Our ref: HA/2017/119688/01-L01
Your ref: LU/243/17/PL
Date: 24 August 2017

CONVERSION & MINOR EXTENSION OF EXISTING RESTAURANT & FIVE BEDROOM FLAT TO CREATE A SHOP UNIT & 6 NO. RESIDENTIAL UNITS (RESUBMISSION FOLLOWING LU/71/17/PL)

56-57 PIER ROAD, LITTLEHAMPTON, WEST SUSSEX, BN17 5LP.

Drawing Title
Proposed Drawing
Lower and Upper Ground Floor Plans
1/100 @ A3

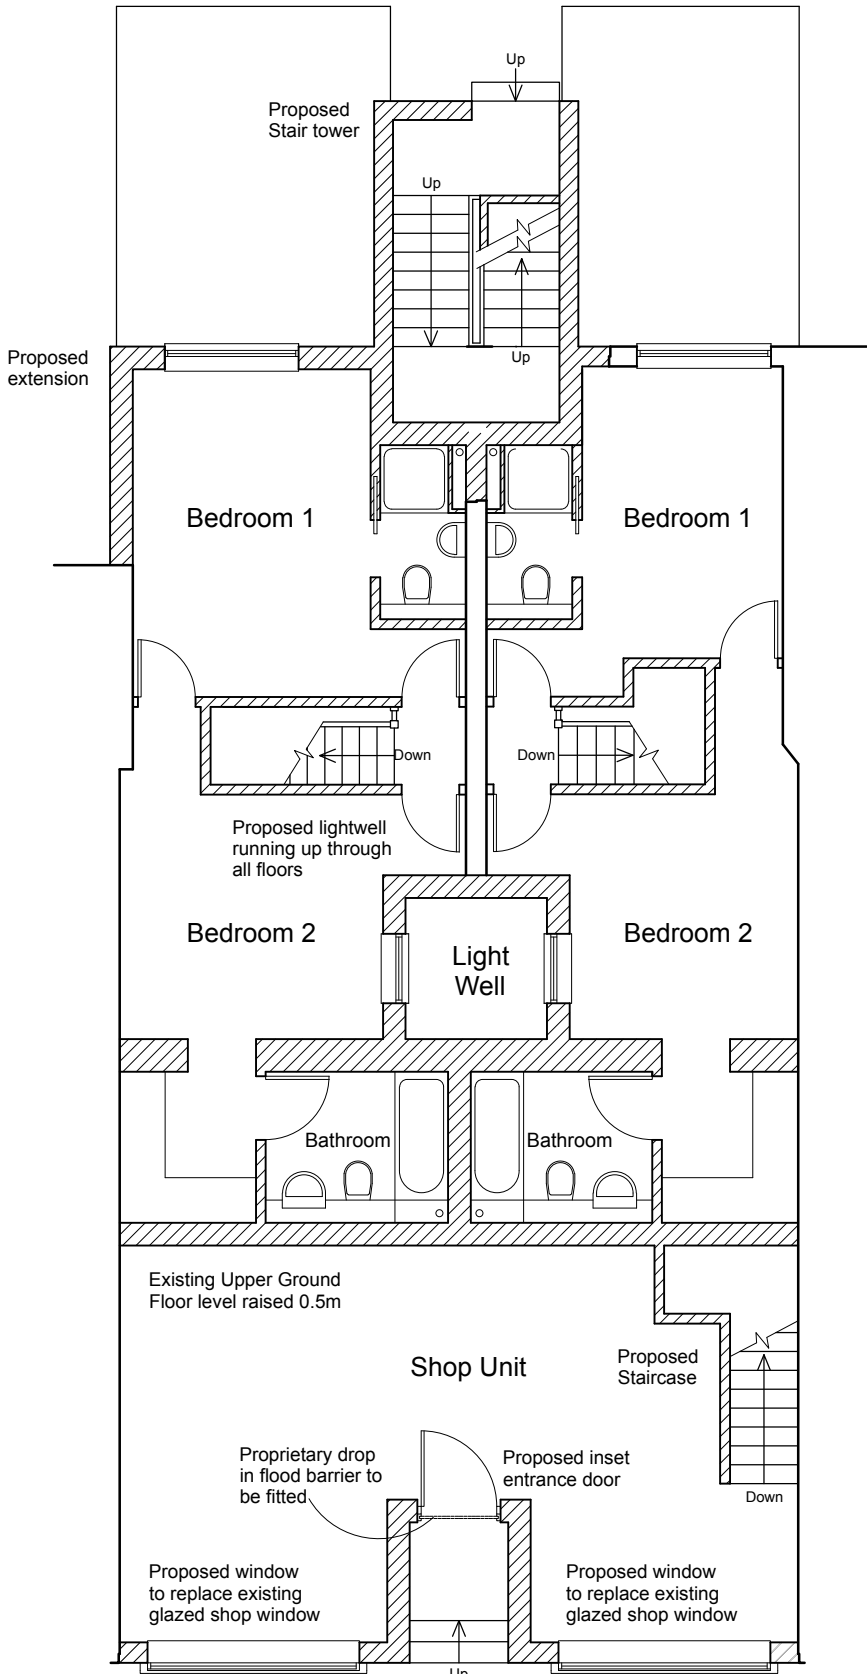
For the proposals to be acceptable it would need to preclude habitable rooms at basement and ground floor level. Development (particularly bedrooms) would need to have a finished floor level set above the 1 in 200year undefended level plus an allowance for climate change of 4.94mAOD.

Basements would only really be suitable for storage/ancillary purposes (as previous use). Ground floor levels could be used for habitable if internal tanking could be installed to the 1 in 200 year plus climate change undefended level of 4.94mAOD, subject to the 'Communities In Practice Guidelines', suitable safe egress and access and Building Control approval.
